Arun District Council
Arun Civic Centre
Maltravers Road
Littlehampton
West Sussex BN17 5LF
Planning & Building Control General Enquiries
Tel: (01903) 737756 Fax: (01903) 730442
Dx: 57406 Littlehampton
Minicom: 01903 732765
e-mail: planning@arun.gov.uk
website: www.arun.gov.uk/planning

24th May 2021

Application No: FG/82/21/PL
Site Address: 11 Ferring Marine Ferring BN12 5PP
Description of works: Variation of condition imposed under FG/127/19/HH relating to approved plans.

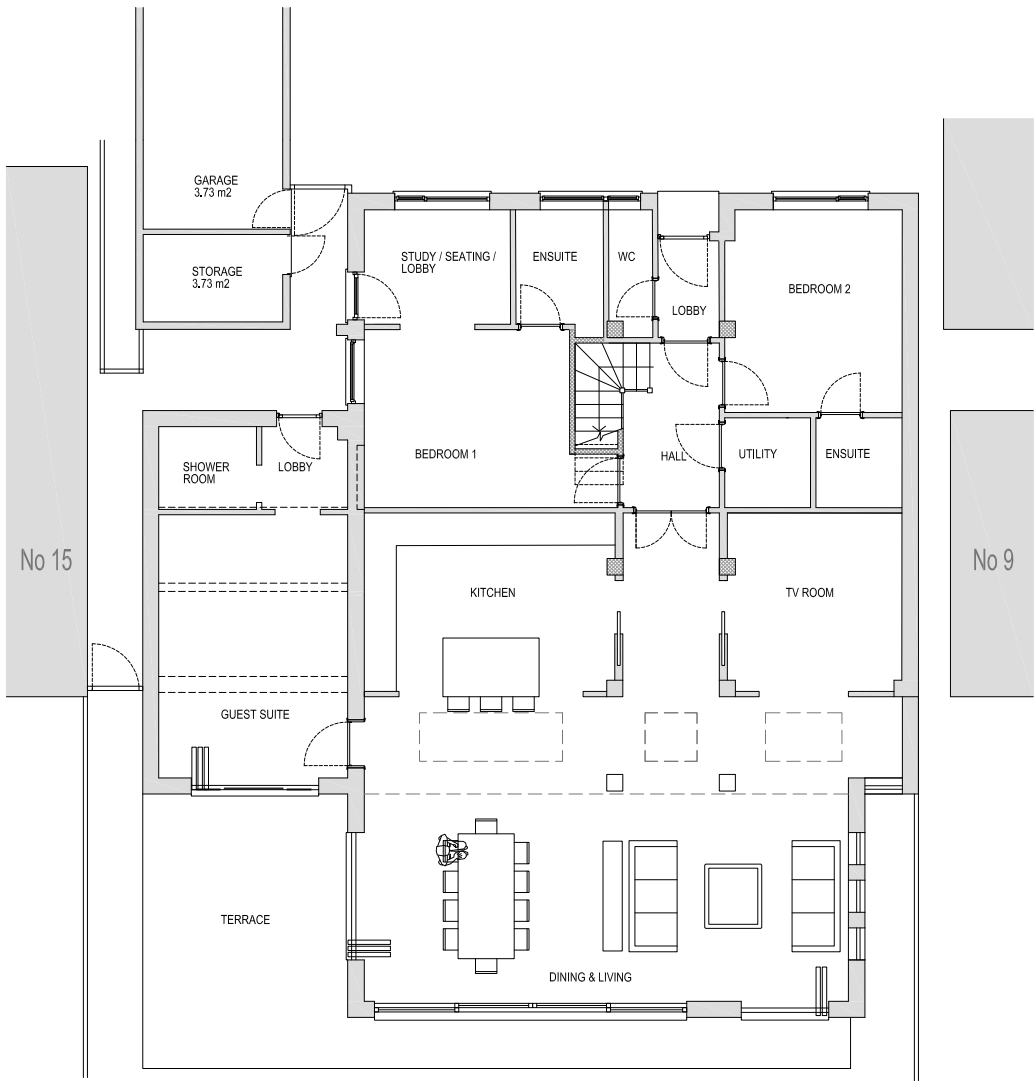
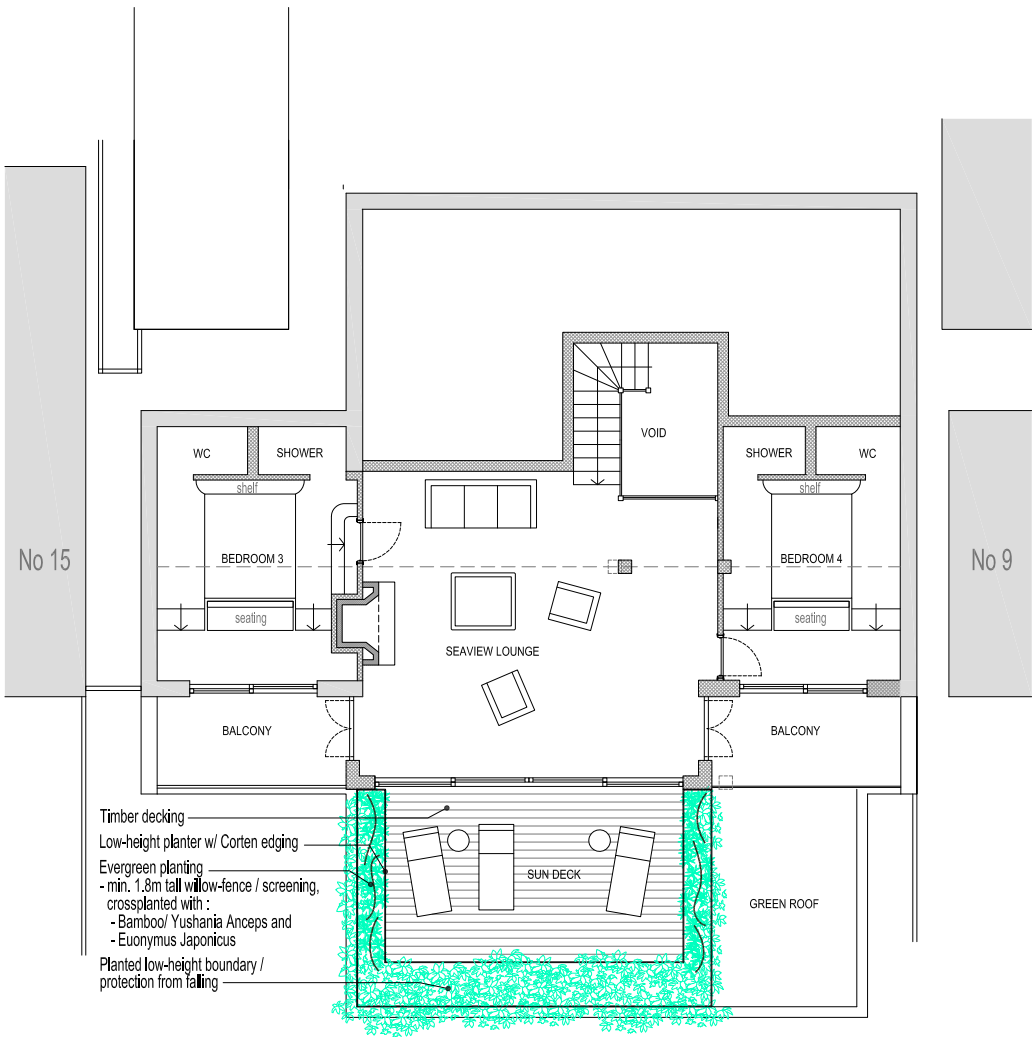
As well as the above as the extension is so far forward from the back of our house, worryingly who ever stands on it they will also now be able to view back straight into our lounge and also into our bedrooms!

PROPOSED
ELEVATIONS AND
MAIN SECTION

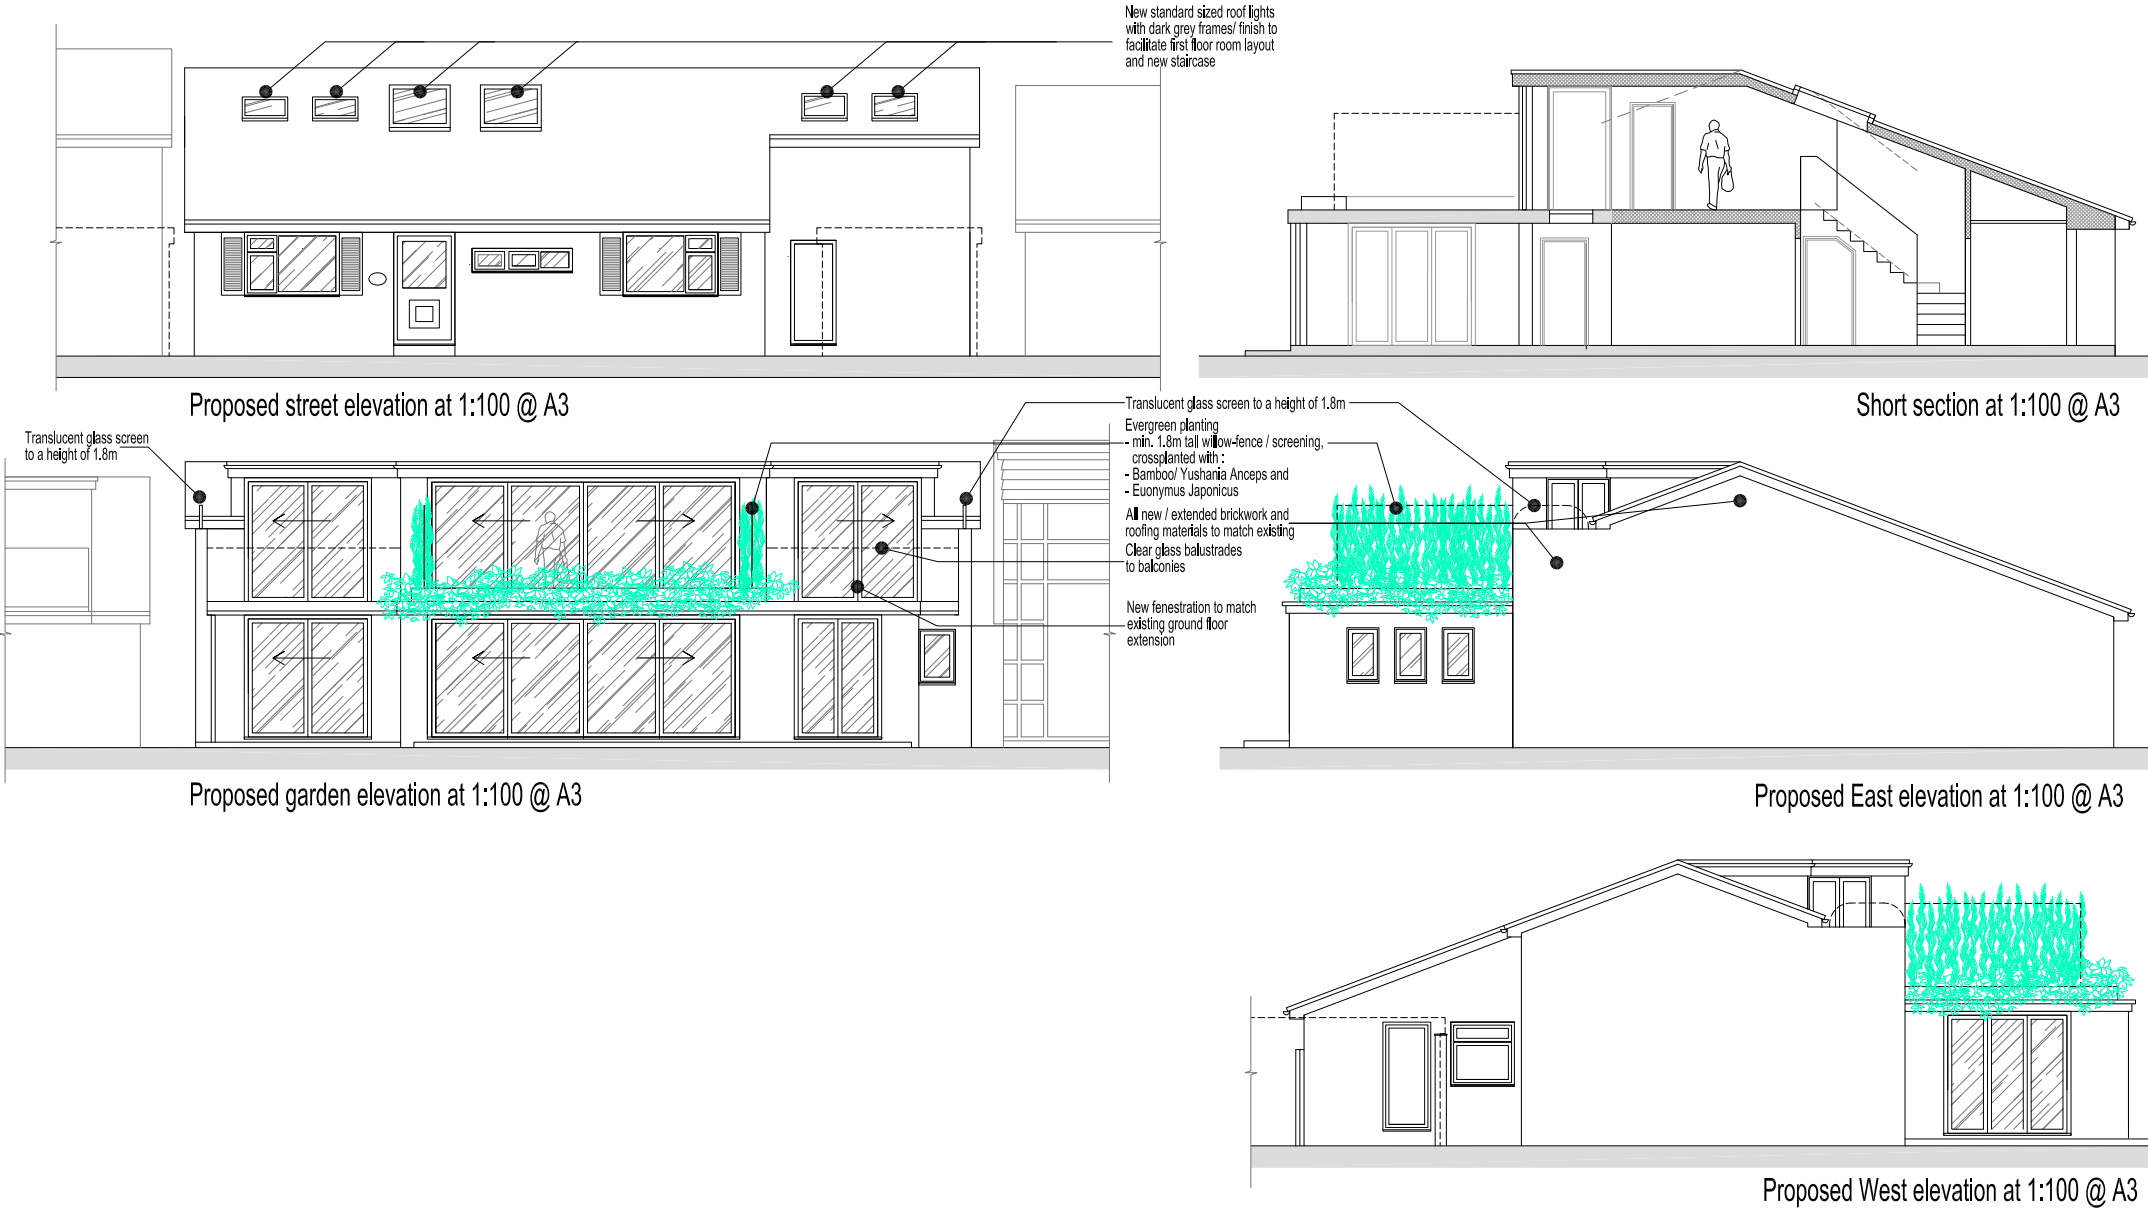
This is a blatant manipulation of the planning system to request a 'Variation of a condition' the planning for the ground floor extension was under permitted development and then the second to form rooms in the loft specifically stipulated that the extension roof has to be a 'green roof' and was not to be used at anytime as a balcony. How can a variation now all of a sudden allow the use of the area as a balcony, it only has planning to be constructed as an extension to the existing house, the roof area does not have planning permission to be used as a balcony.

The original drawing number P5 C dated 27/08/19 clearly shows a clear glass balustrade that was part of the consented/approved planning to be erected as a 'Juliet balcony' along the entire sDATA ERROR!!!
